Our Ref: BE/127/12/A
Your Ref:

Town & Country Planning (Control of Advertisement) (England) Regulations 2007 (as amended)
Application for Consent to Display an Advertisement(s)

Development Various non-illuminated & internally illuminated signage

Location Former LEC Site Shripney Way Bognor Regis

Proposed Covered Trolley Bay Example
NTS

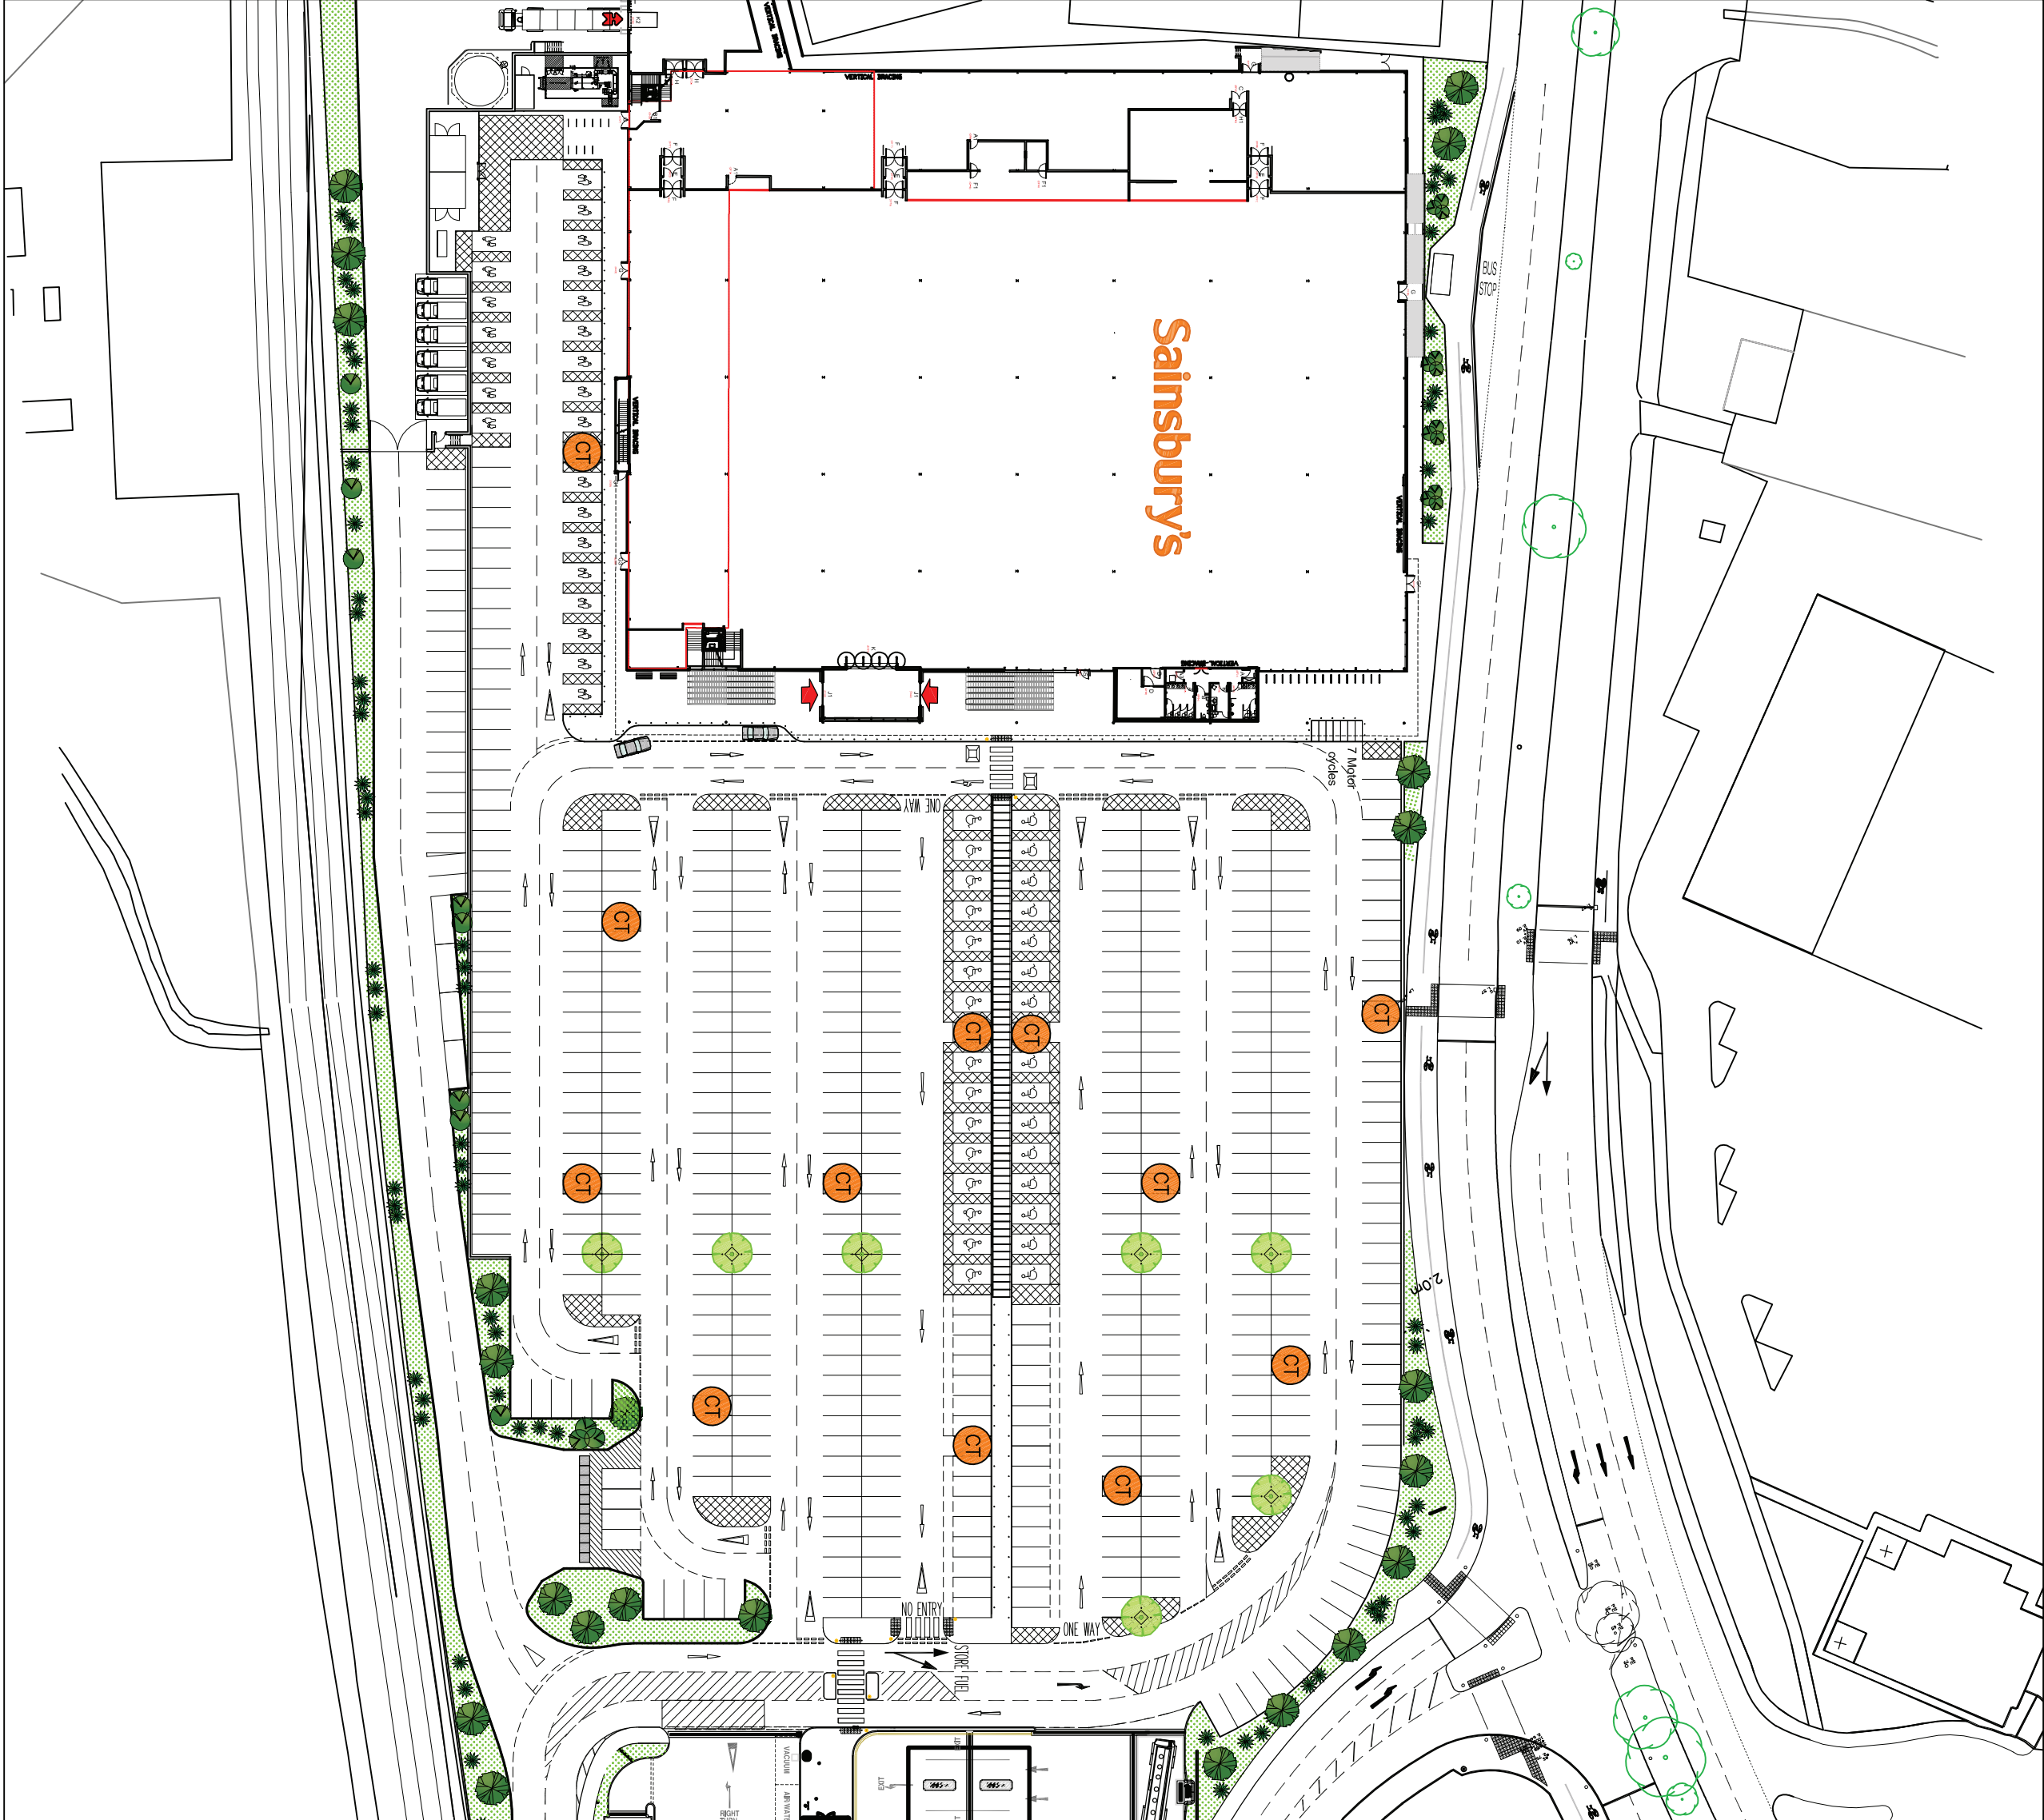
- The red edge on the proposed site plans: CHQ.12.9691-PL11 and CHQ.12.9691-PL12 must match the location plan 2486/200 Rev A. Please amend.
- Plan no. CHQ.12.9691-PL14 shows 11 trolley bays, however the schedule states there are 24 trolley bay logos (2 per bay) which would suggest that there should be 12 trolley bays. Please amend the schedule/plan as applicable.
